December 6, 2017

RE: Flying Horse North Preliminary Plan  
El Paso County, Colorado  
Traffic Impact Analysis  
LSC #174870

OVERALL SITE PLAN AND SHEET KEY

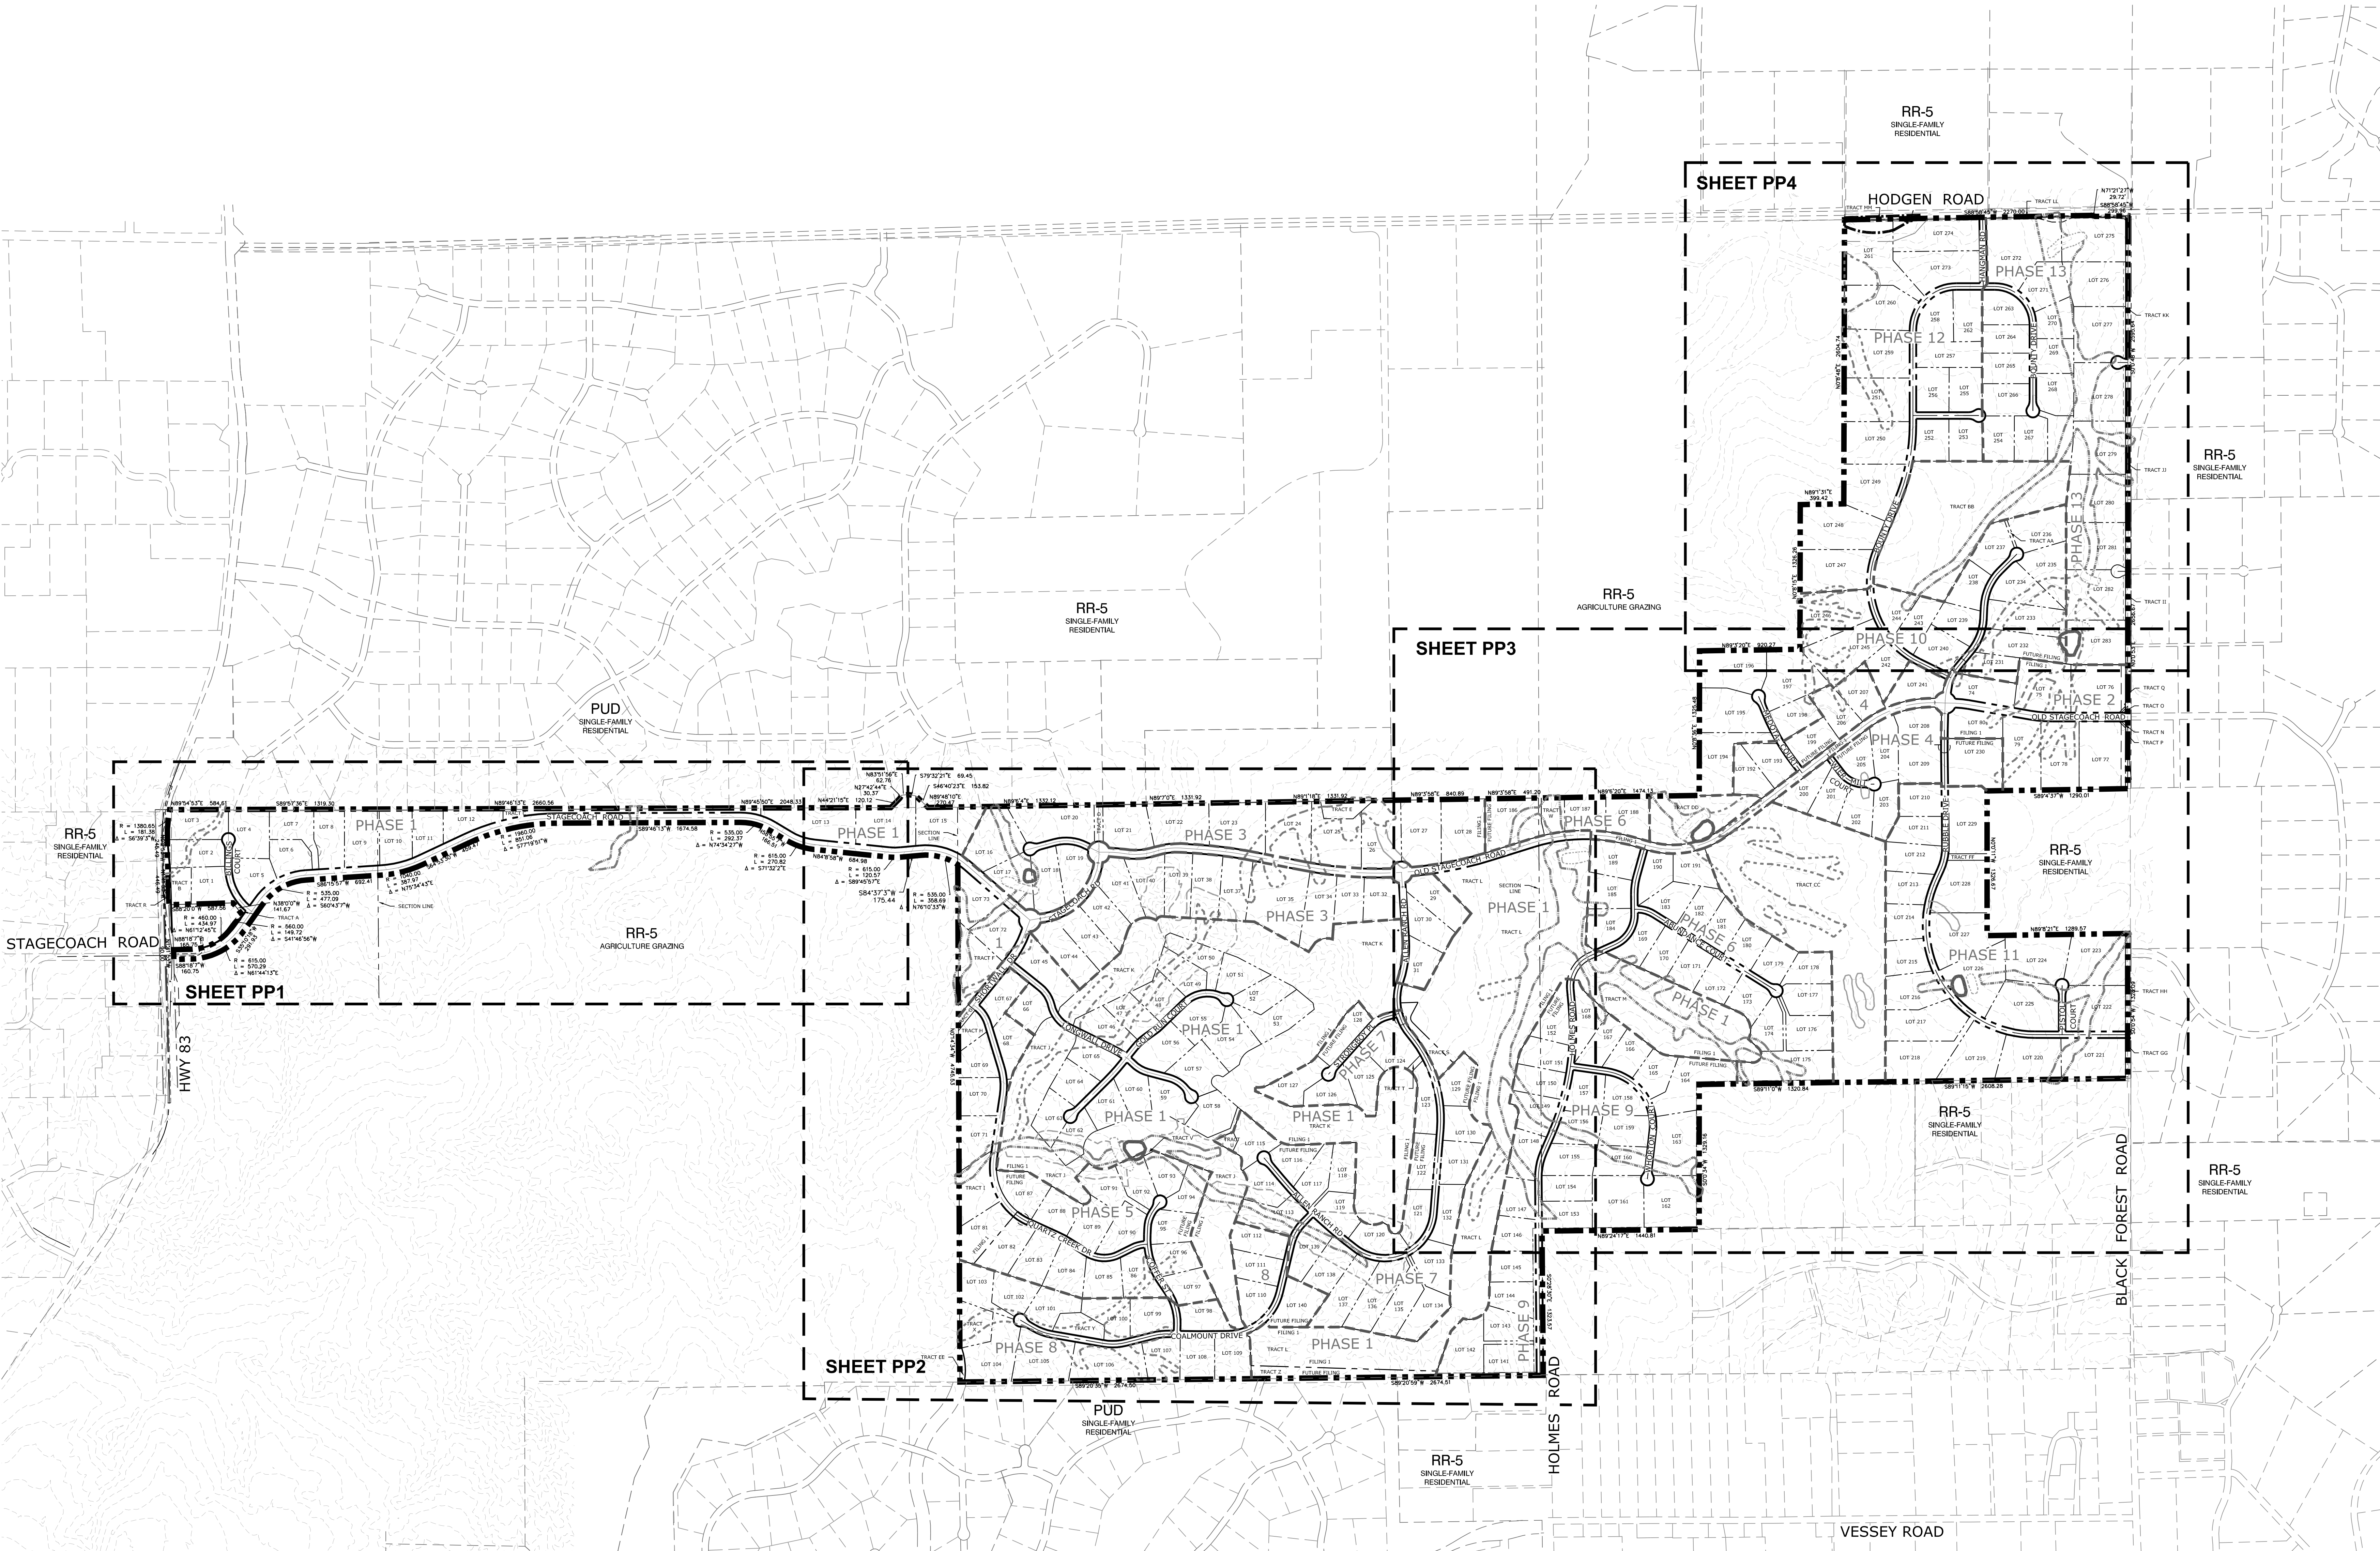
Provide an exhibit for the roadway classifications. The preliminary plan also identifies some roadway segments as Rural Minor Collector.
